## Comments on the Applicant's D6 Submissions

This document sets out the comments by Cambridgeshire County Council (**CCC**) and Fenland District Council (**FDC**) (together, **the Councils**) on the Applicant's Deadline 6 (**D6**) submissions. The tables below set out the document in question that the Councils are commenting on, together with the relevant paragraph or reference number.

**Figure 10.1iv**  
**Cromwell Road/New Bridge Lane Signal Scheme - General arrangement**

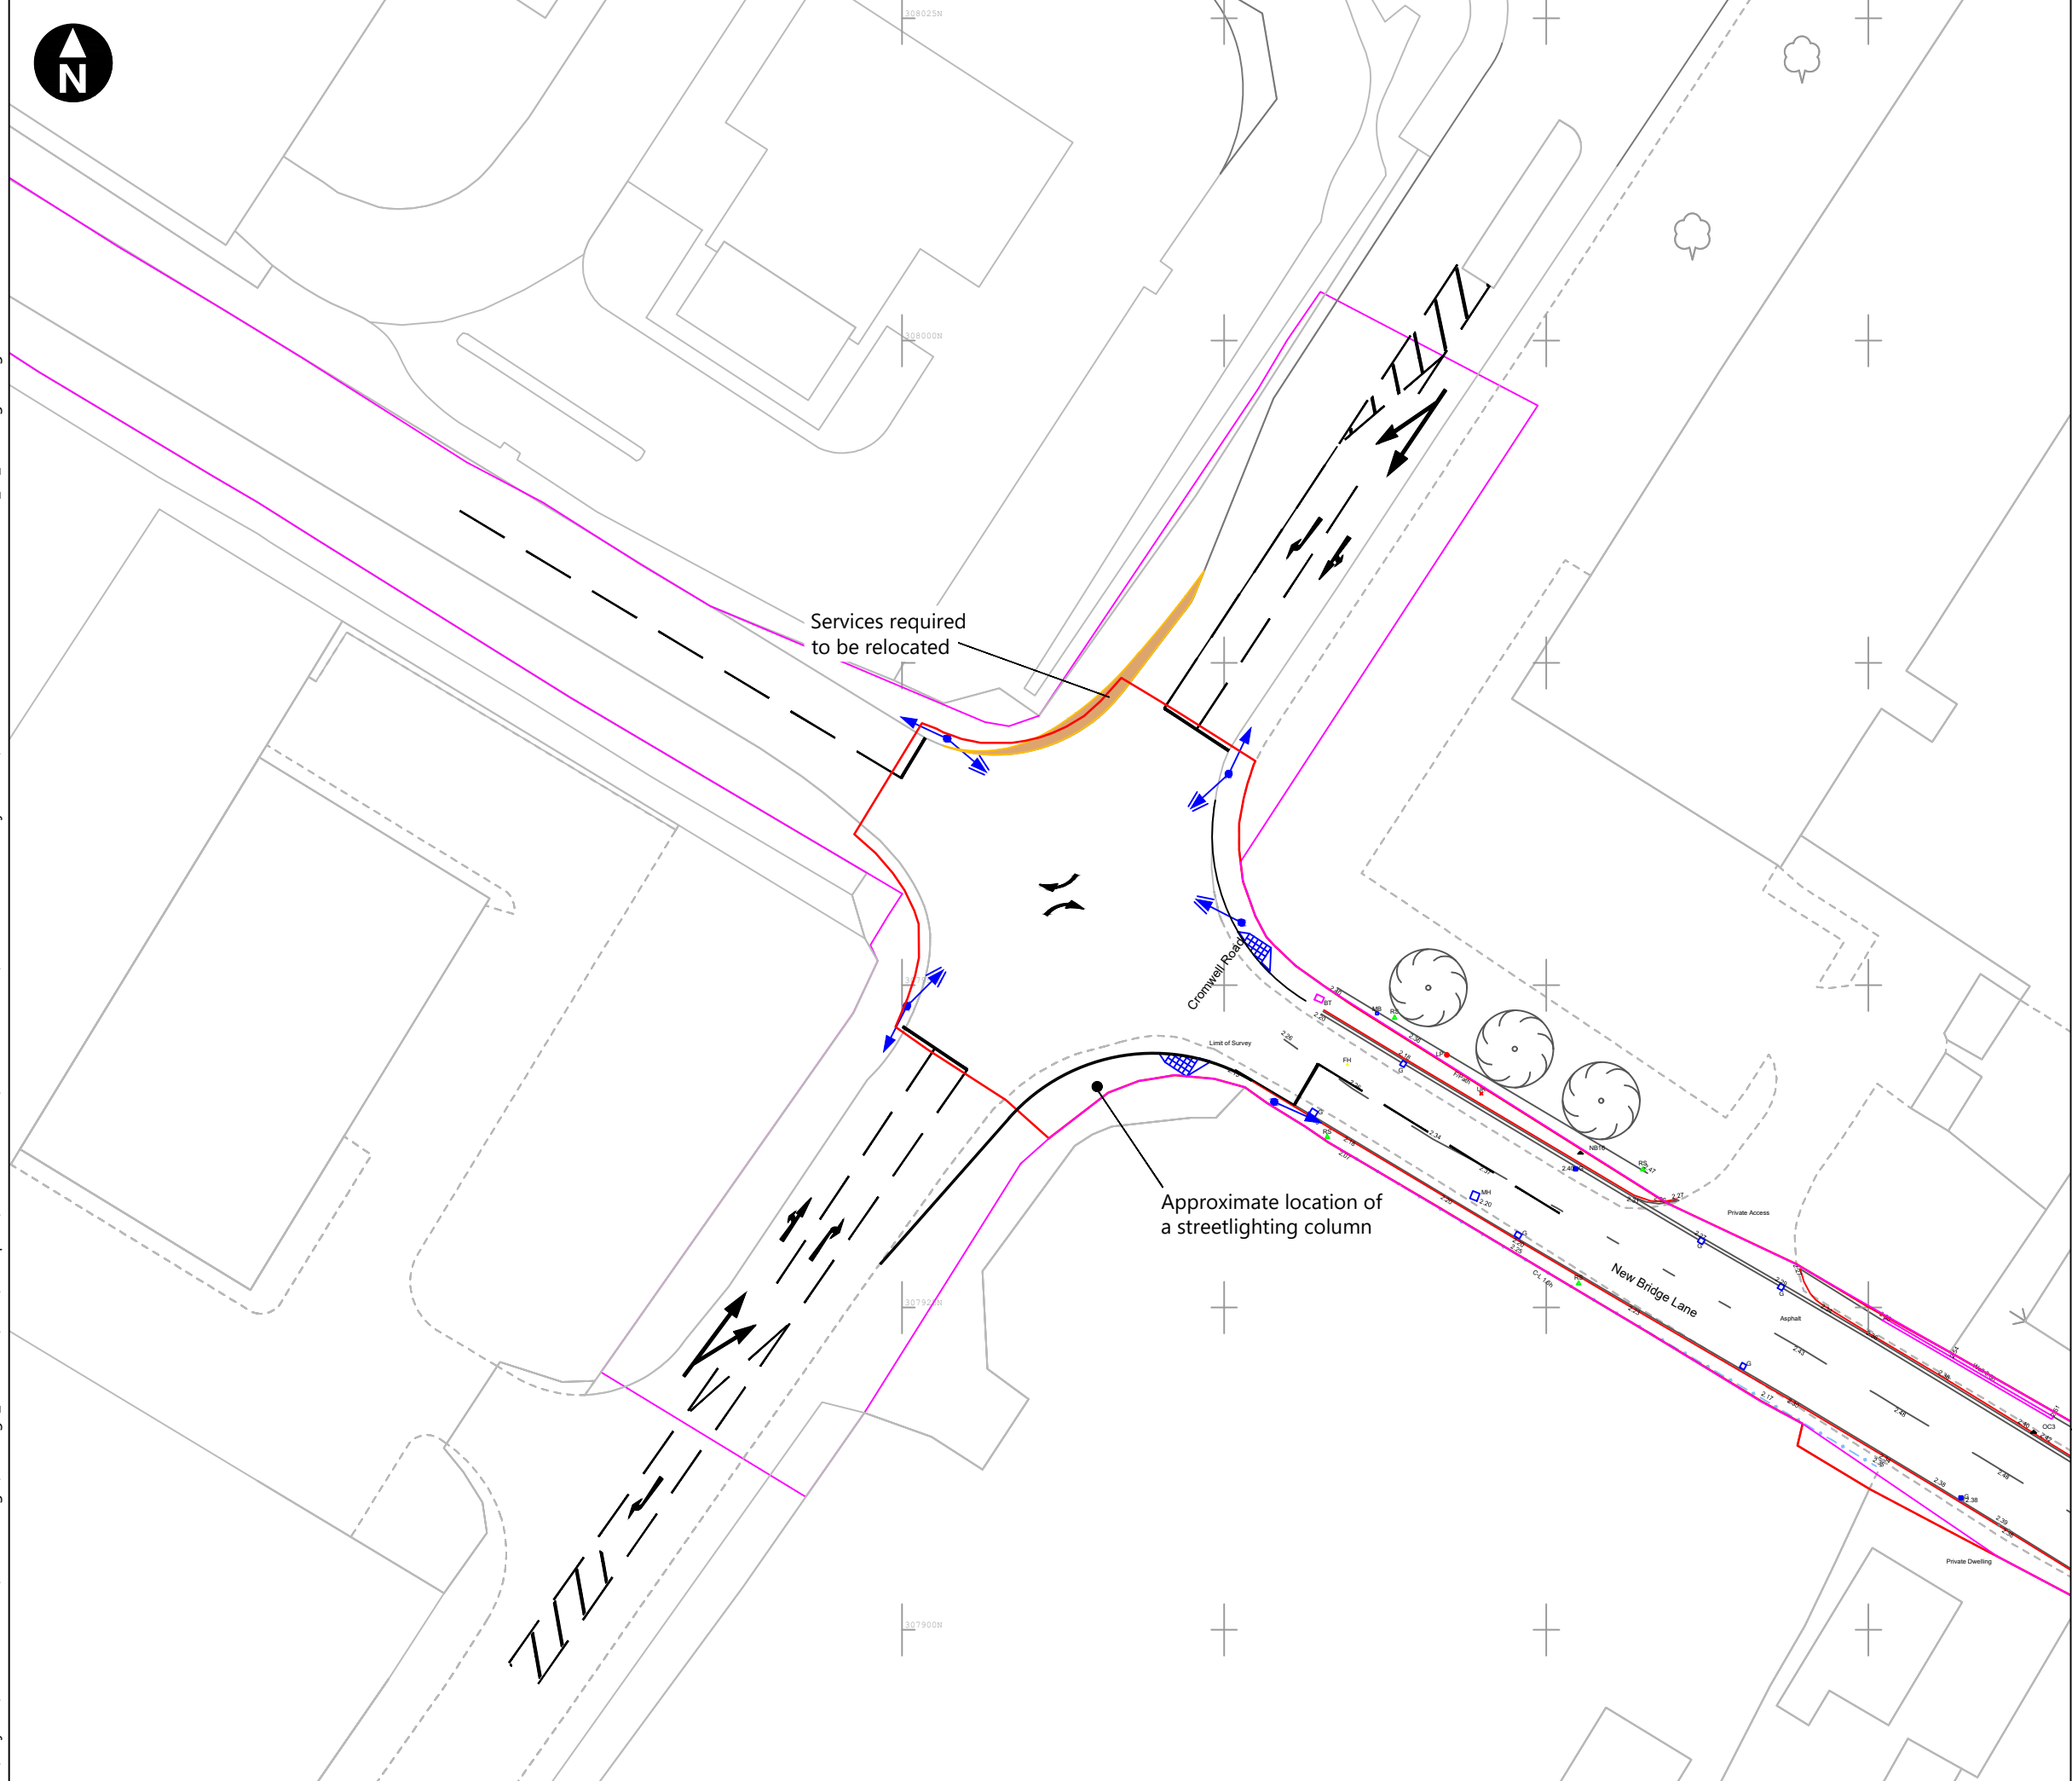
Topic	Paragraph Number	Councils' Comment
<i>General and Cross-Topic Questions</i>		
Signalisation of Cromwell Road / New Bridge Lane Junction	GCT.2.3	The Applicant has noted the meeting of 6 July 2023 that took place with CCC in relation to the re-design of the Cromwell Road/New Bridge Lane junction. CCC acknowledges that additional modelling information with regard to the signals will be provided by the Applicant.

<p>However, the Applicant has not noted a key concern raised by CCC at that meeting – that the powers of acquisition to be included in the DCO, in relation to land currently owned by Tesco, may not be sufficient to ensure that all new infrastructure at the junction can be adopted by CCC as highway maintainable at public expense.</p> <p>CCC understands that the Applicant is engaging its solicitors on this matter, but has yet to receive any further information or proposal from the Applicant. CCC will continue to engage constructively with the Applicant in pursuit of an acceptable outcome on this issue.</p>
<i>Principle and Nature of Development (inc. Waste Recovery Capacity and Management Waste Hierarchy)</i>		
Principle and Nature of Development (inc. Waste Recovery Capacity and Management Waste Hierarchy)	PND2.1	<p>The Memorandum of Understanding (MoU) between the Waste Planning Authorities (WPA) of the East of England is currently being reviewed by the East of England Waste Technical Advice Body (formed of all East of England Waste Planning Authorities), with a view to updating the Memorandum. It is expected that the commitment to net self-sufficiency will remain in the new version.</p> <p>All planning authorities are under a Duty to Co-operate in respect of strategic matters, of which waste management capacity is one such topic. Memoranda and Statements of common ground such as these are the mechanisms by which that is largely achieved, and regular review is not unusual.</p>

DCO Requirement 29: Waste Area Plan

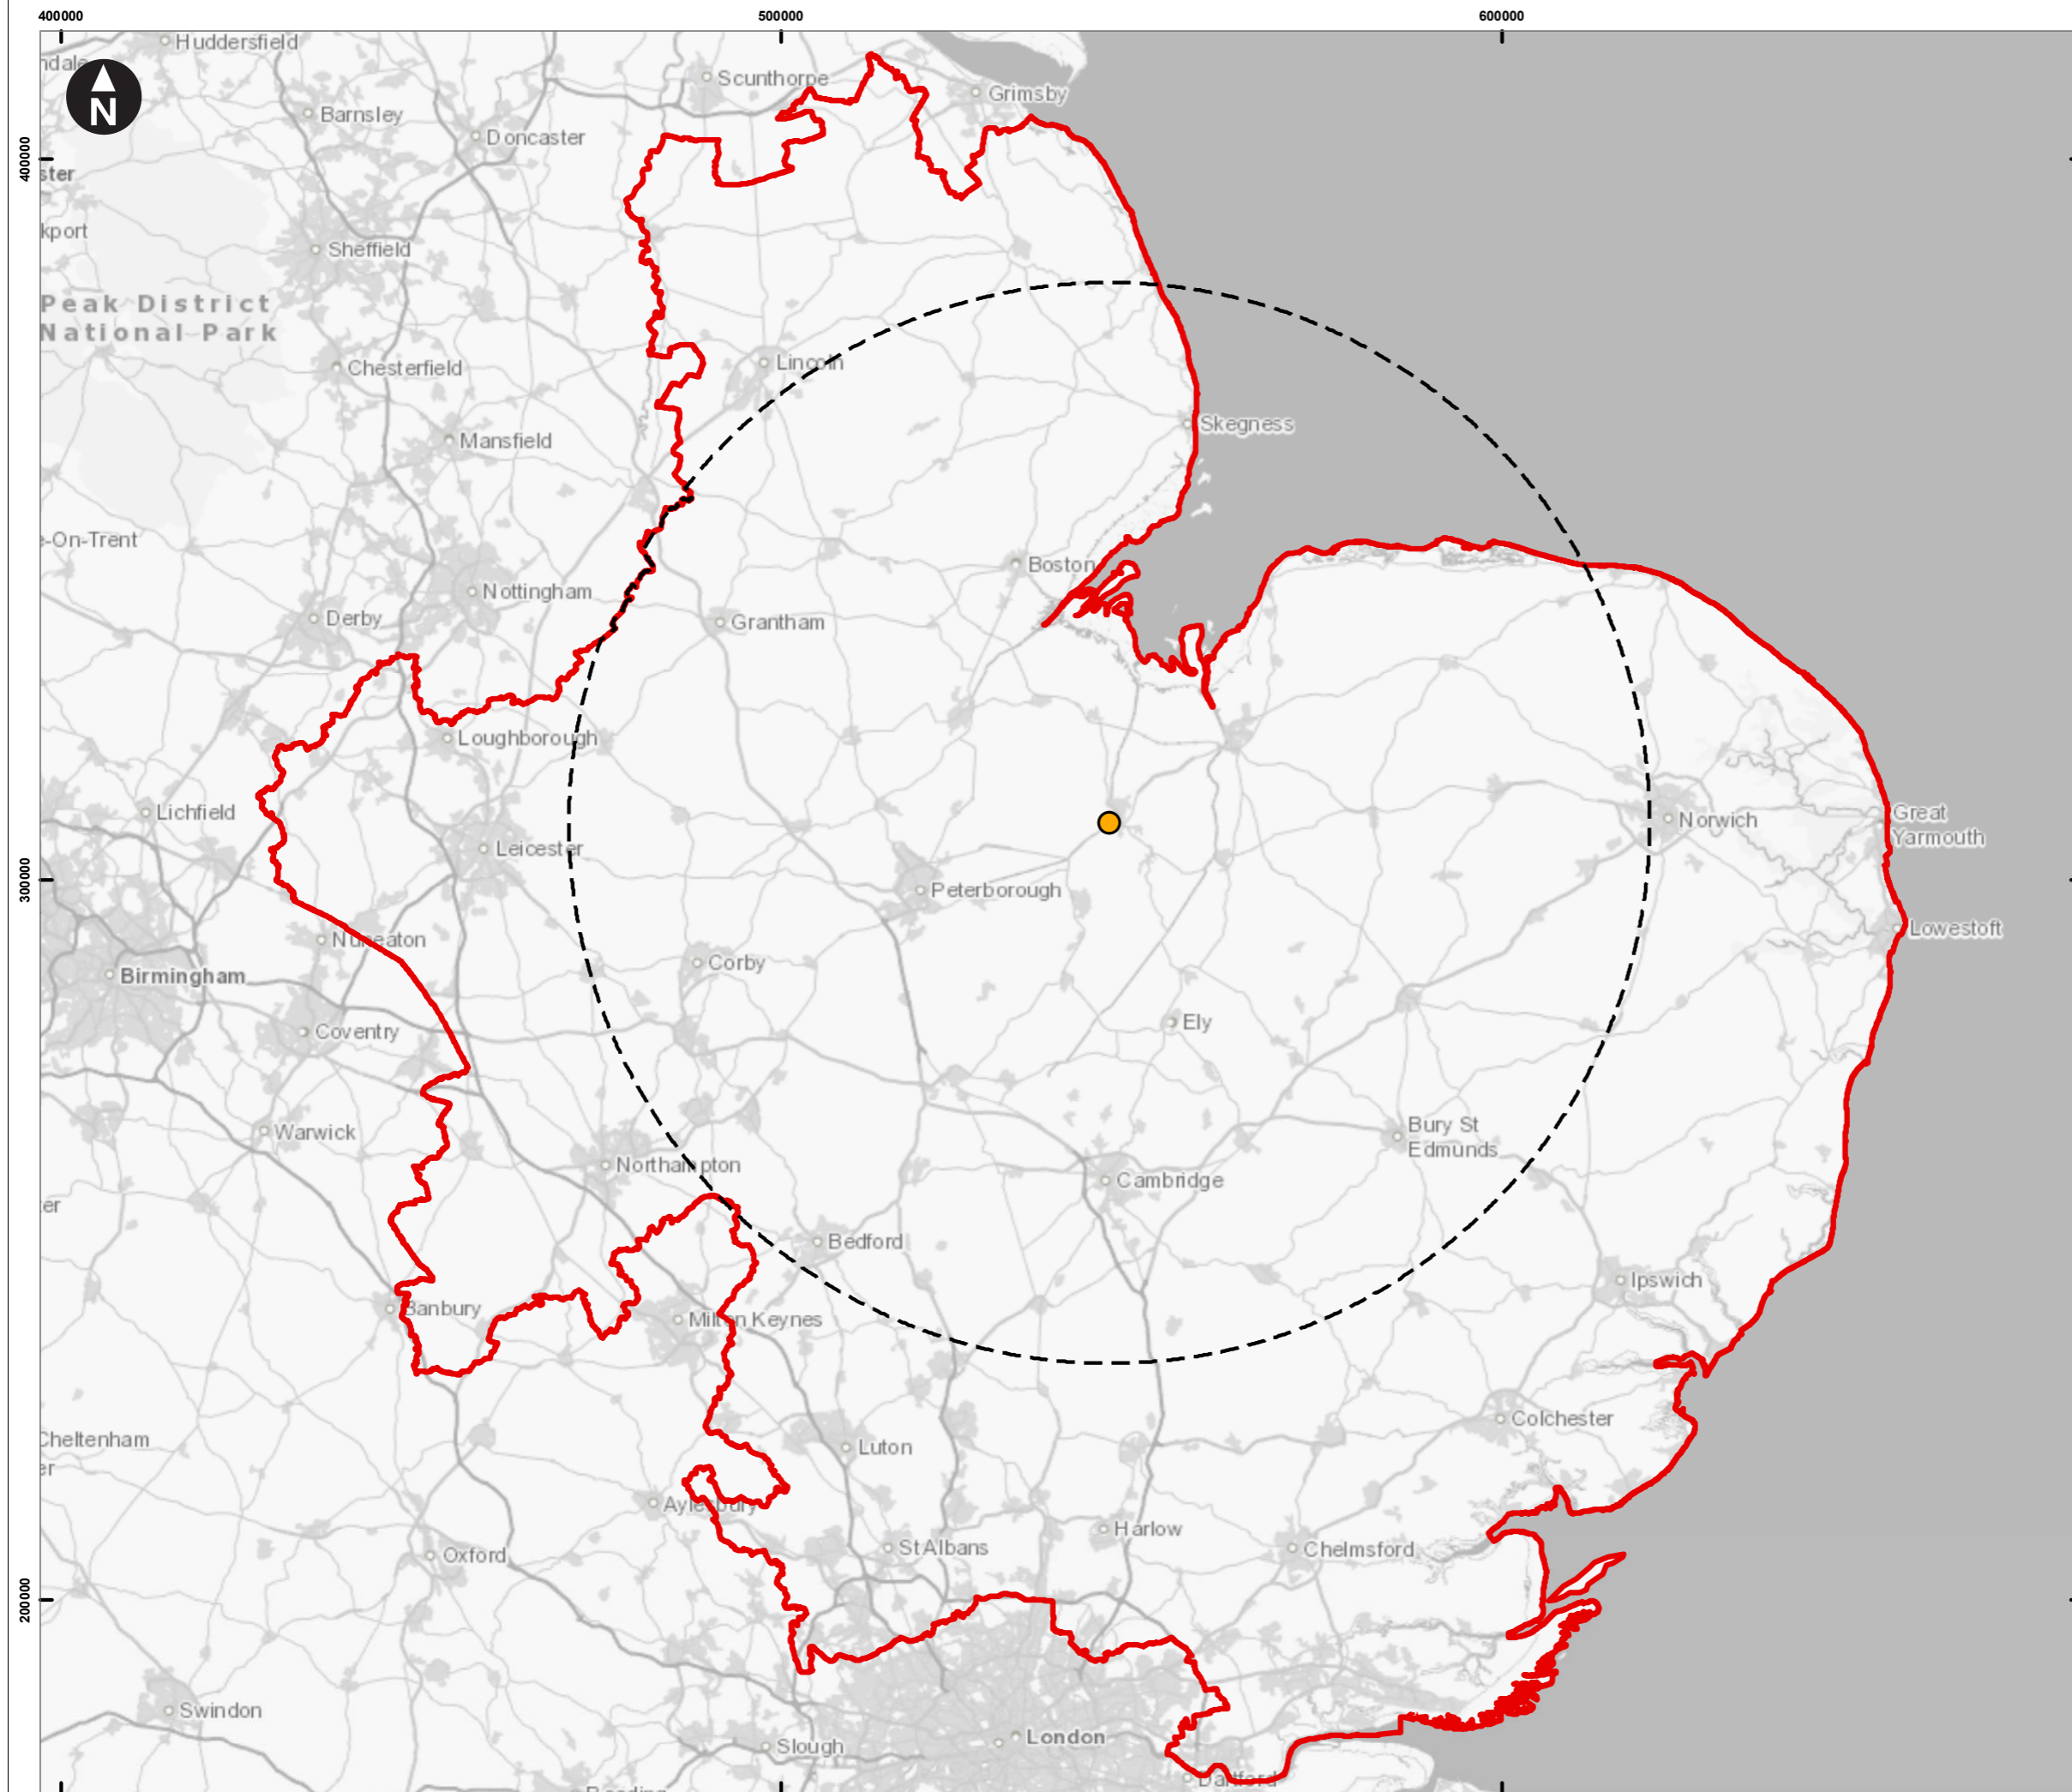
Topic	Paragraph Number	Councils' Comment
Waste Area Plan	Map	CCC can confirm that the map is the agreed map discussed between Applicant and Council for the Waste Area Plan.
